Alan Varela, Director

February 6, 2025

**Re: Residence Inn & Food Hall at 1201 Central Ave NE
Erosion and Sediment Control Plan
Engineer's Stamp Date 2/4/25 (K15E034D)**

210046 PROJECT NUMBER C102 SHEET NUMBER

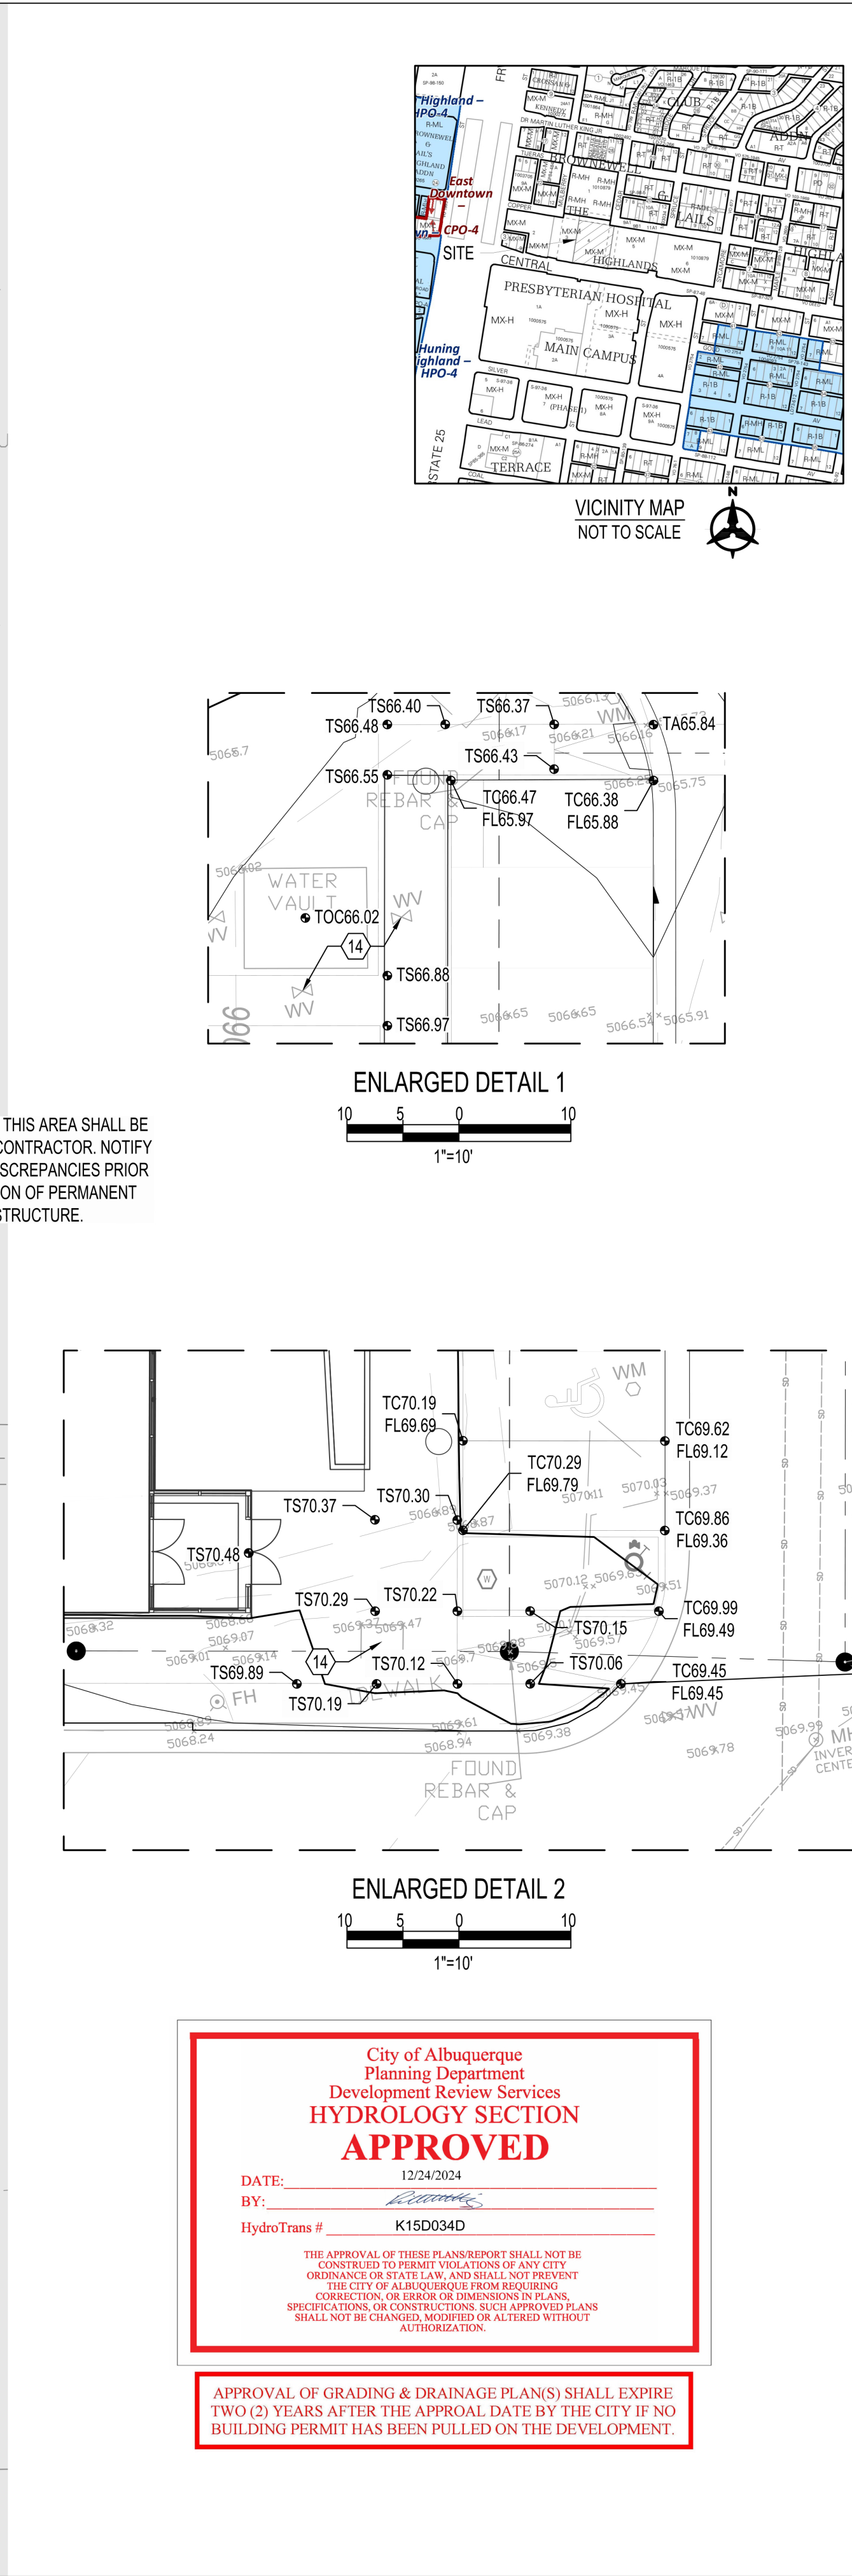
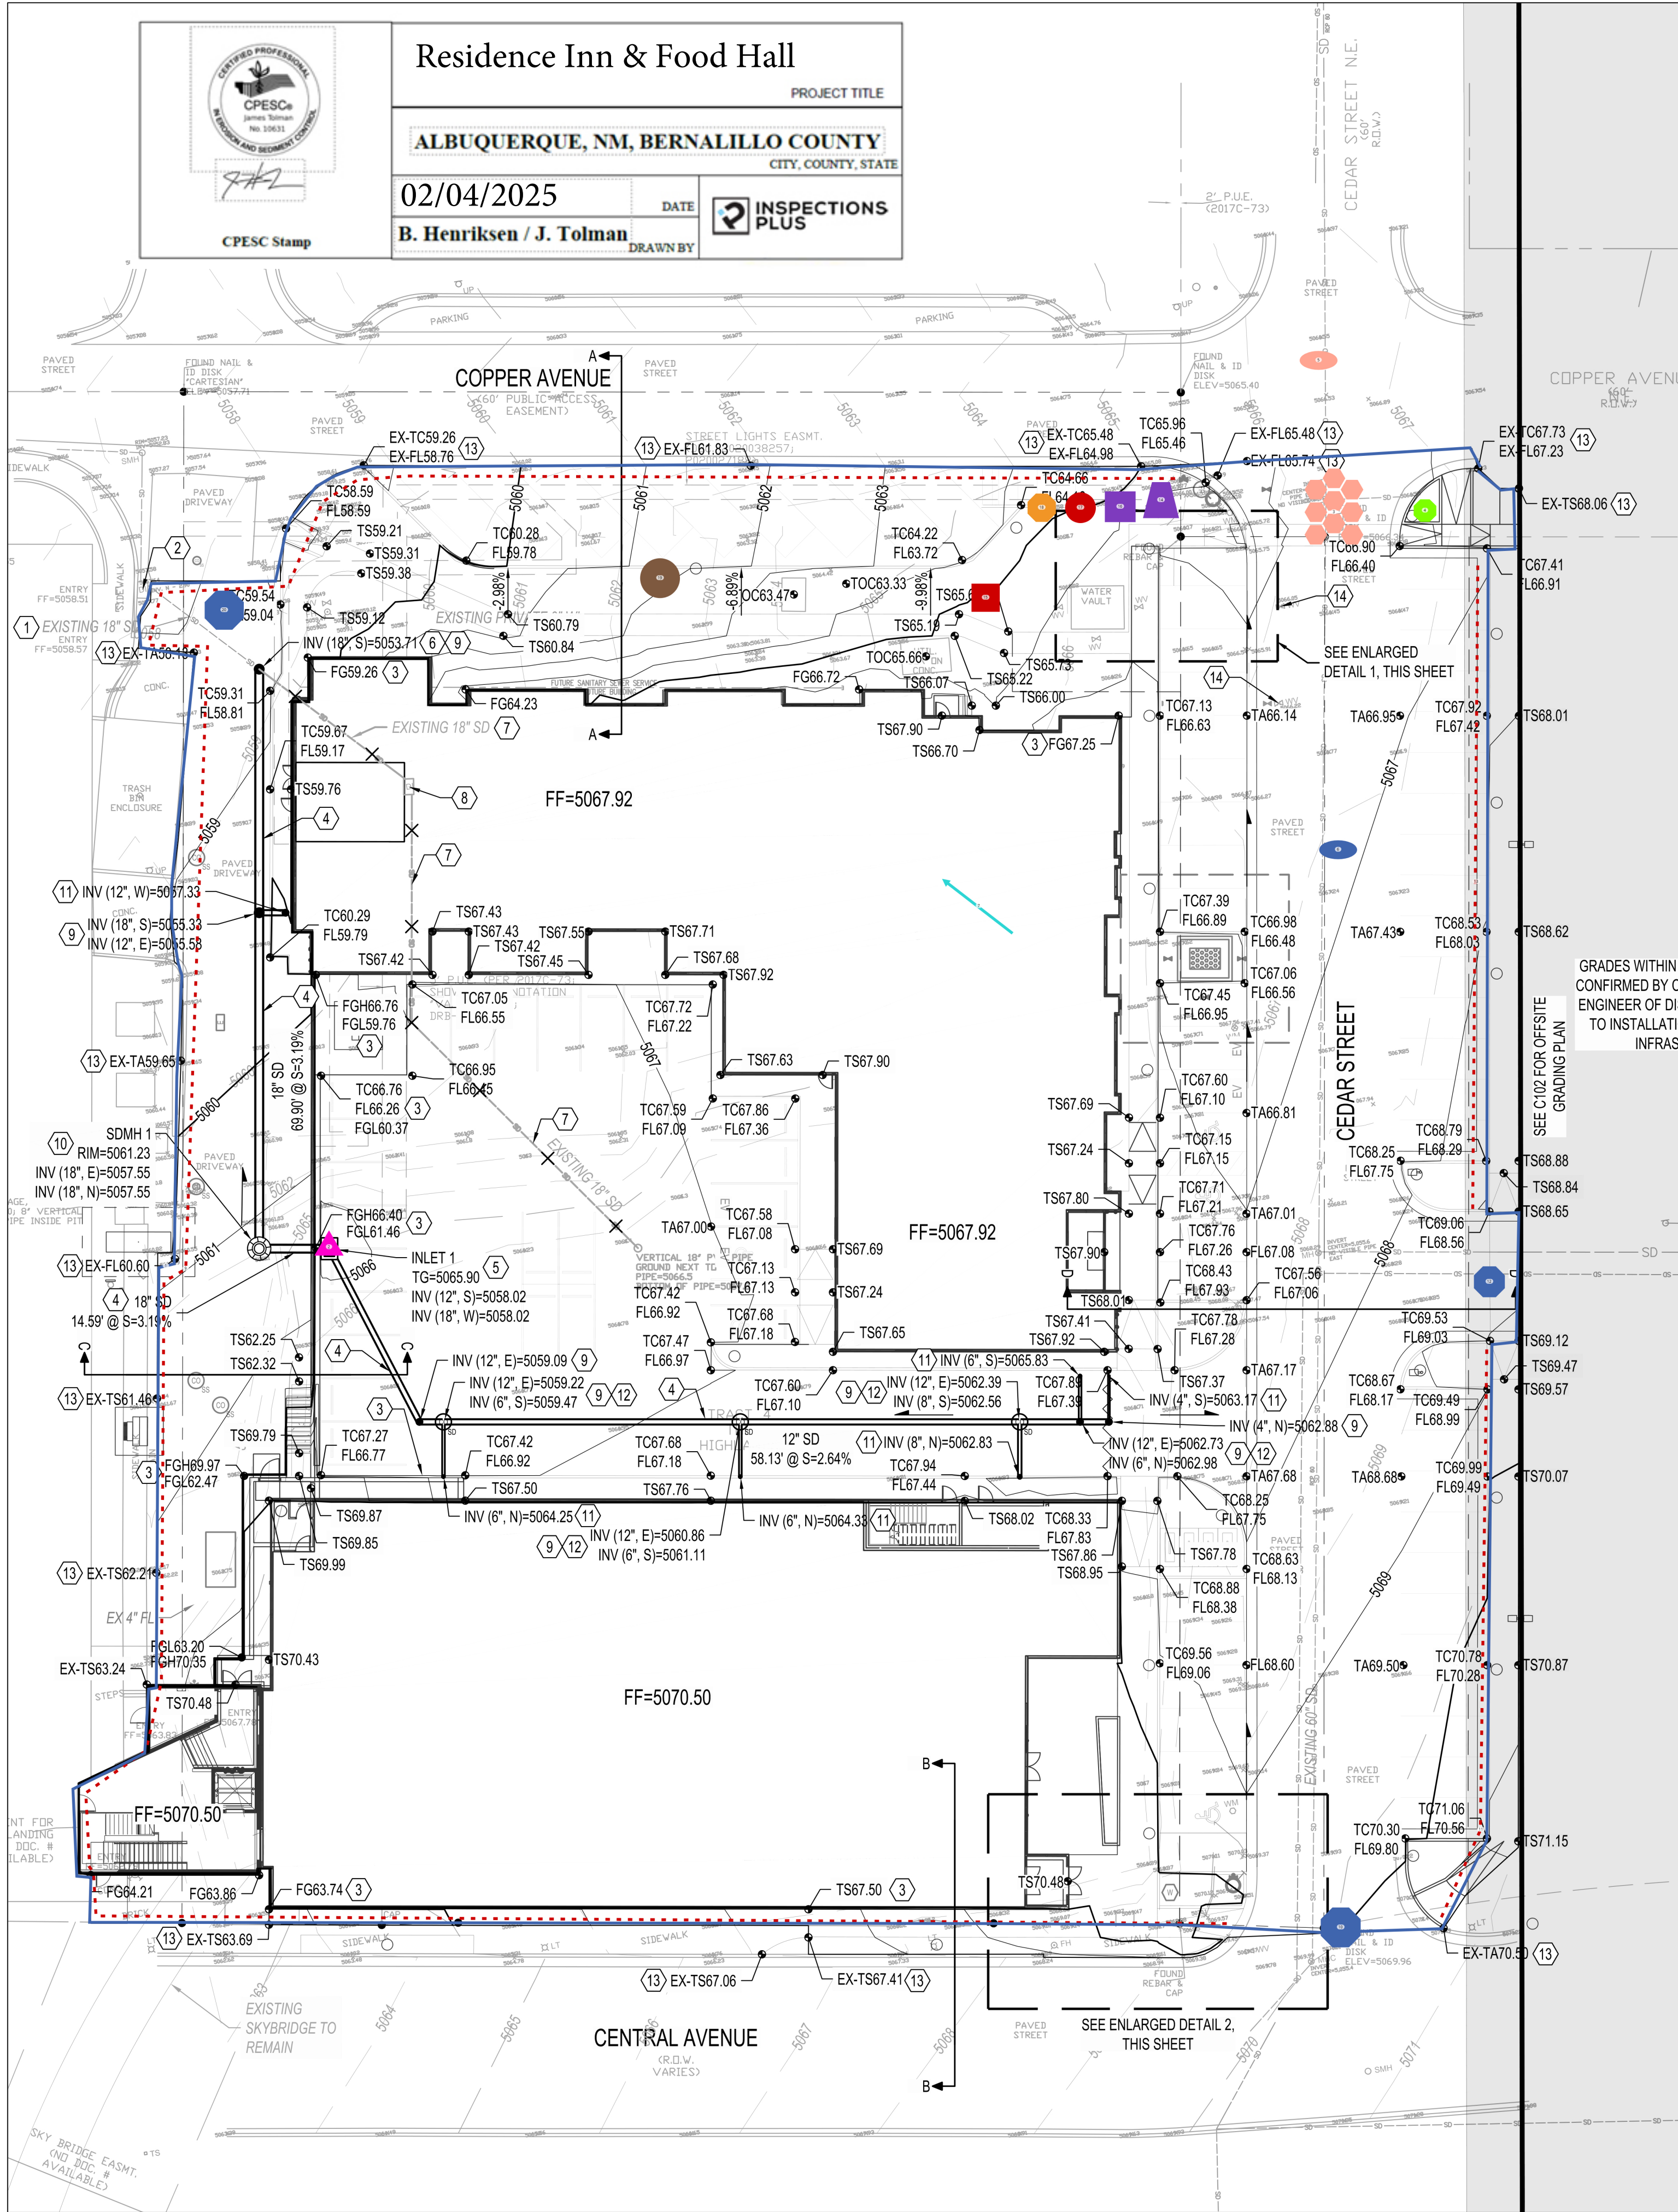
2. Identify locations of concentrated flow paths that enter and exit the disturbed areas. Identify locations where sheet flow enters and exits the disturbed area. Show on-site drainage patterns of stormwater before and after major grading activities as required by CGP 7.2.4.f.

3. Temporary sediment traps are required upstream of the two concentrated flow discharge locations.
4. The construction exits must be moved out of the path of the concentrated discharges.

6. The limits of disturbance and property boundary are not in the same location, so a single line can't be used to represent them both.
7. Update the engineer's stamp date on all sheets each time a change is made to any of the ESC plan sheets.
